**T-MOBILE SITE NUMBER:** DN06163A  
**T-MOBILE SITE NAME:** SPRINT RETAIN SITE DN14XC247  
**T-MOBILE PROJECT:** SPRINT RETAIN

**SBA SITE ID:** CO46103-A  
**SITE ADDRESS:** 7353 WEST HIGHWAY 24  
**JURISDICTION:** MANITOU SPRINGS, CO 80829  
**EL PASO COUNTY**

TITLE SHEET

C-1.1

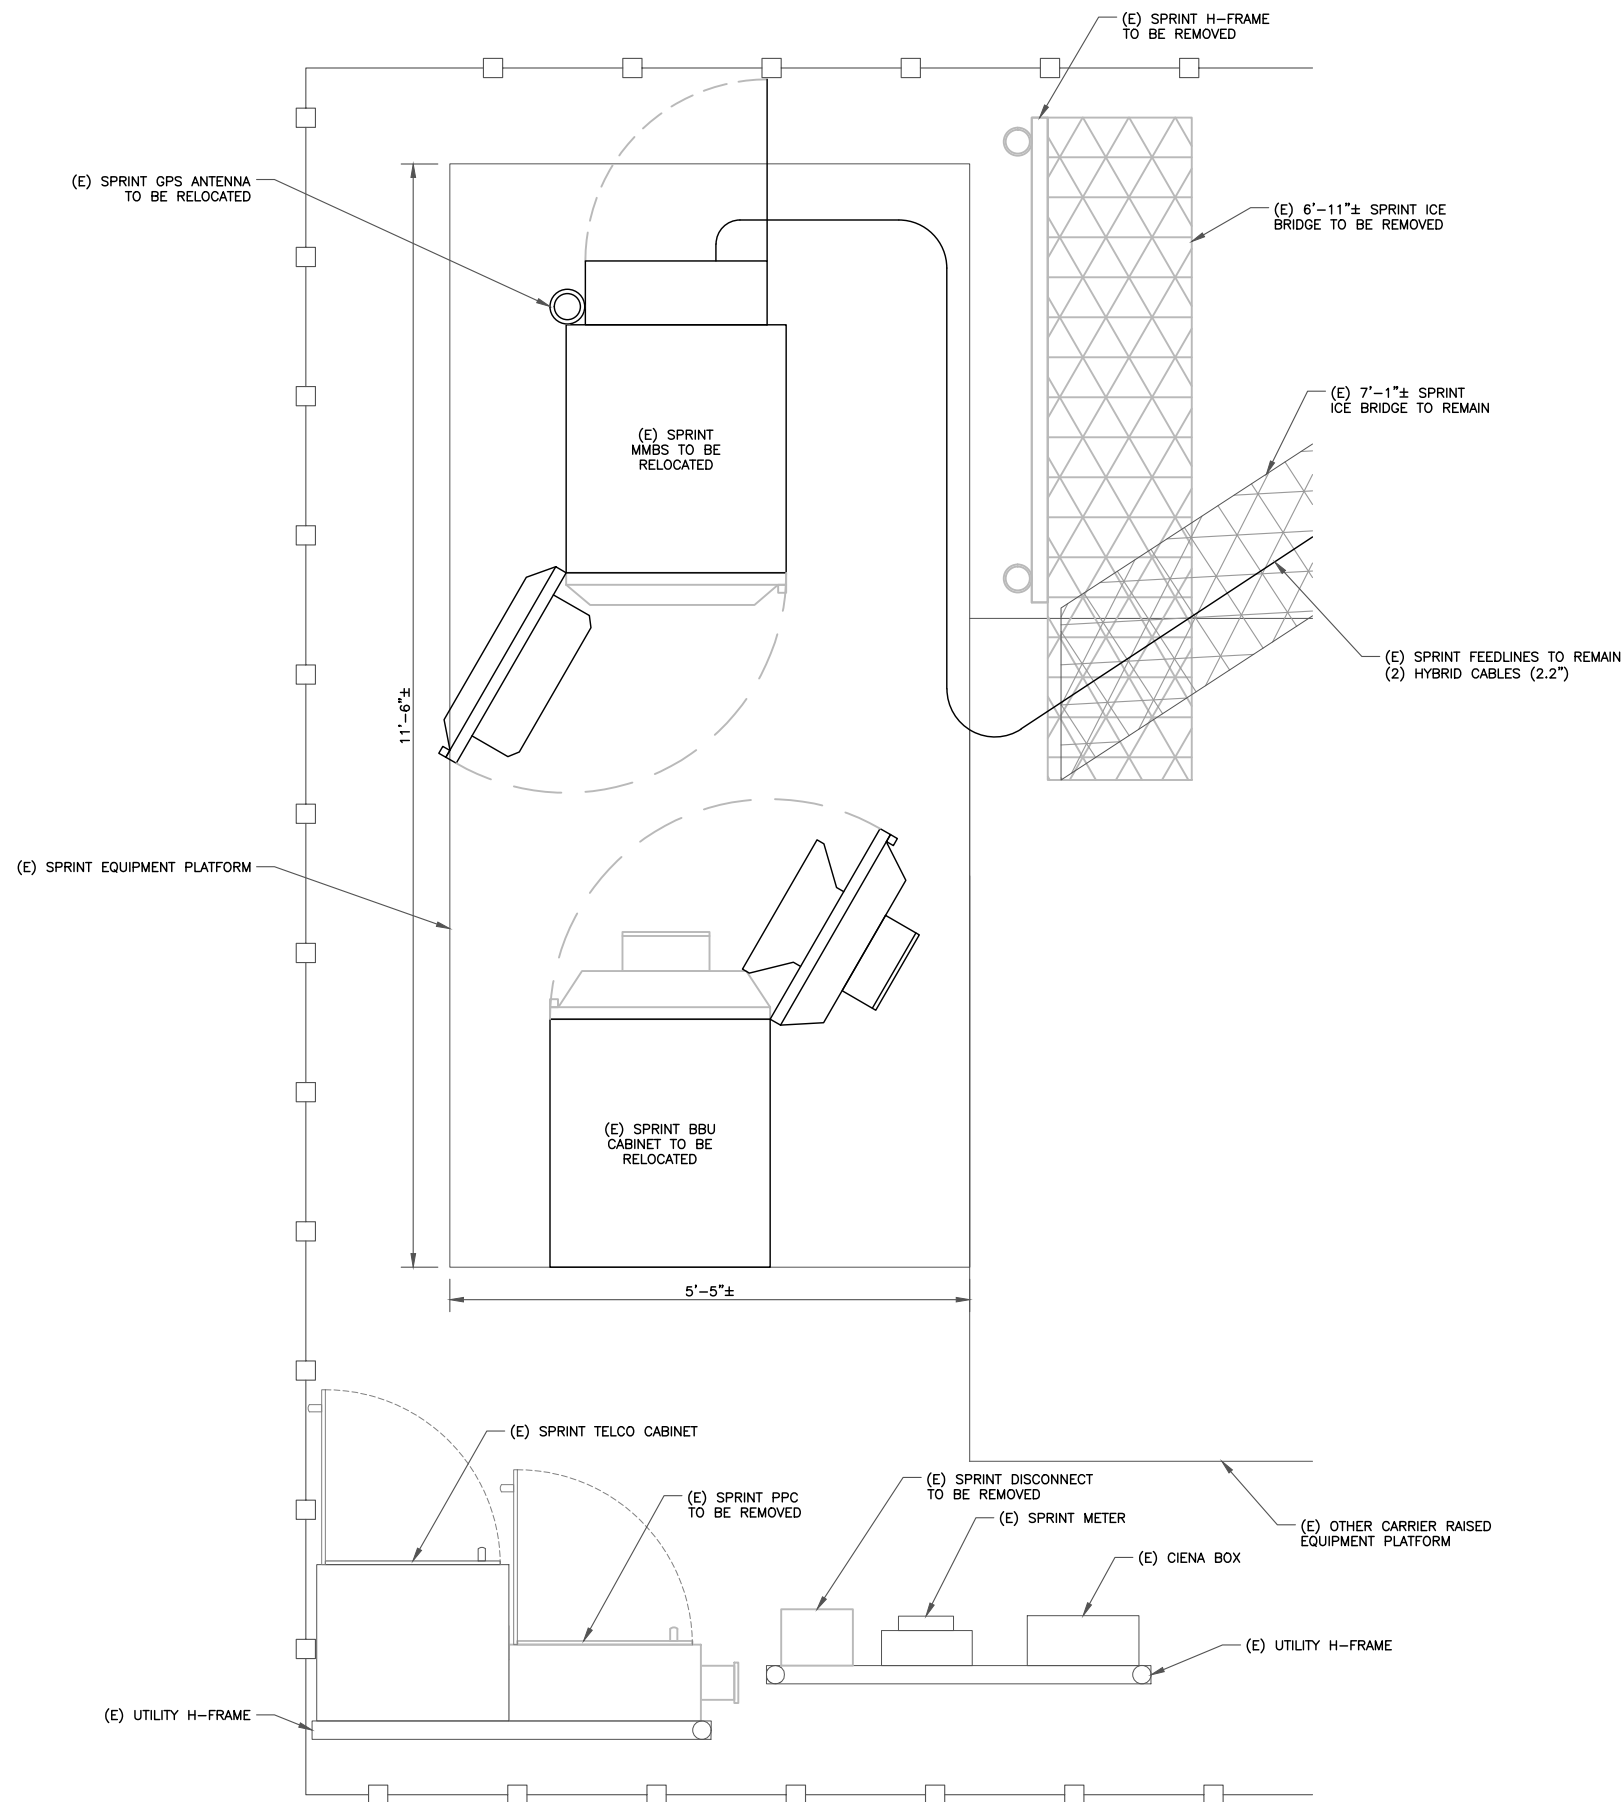
please add the following to the site plan:  
 -Parcel ID Number
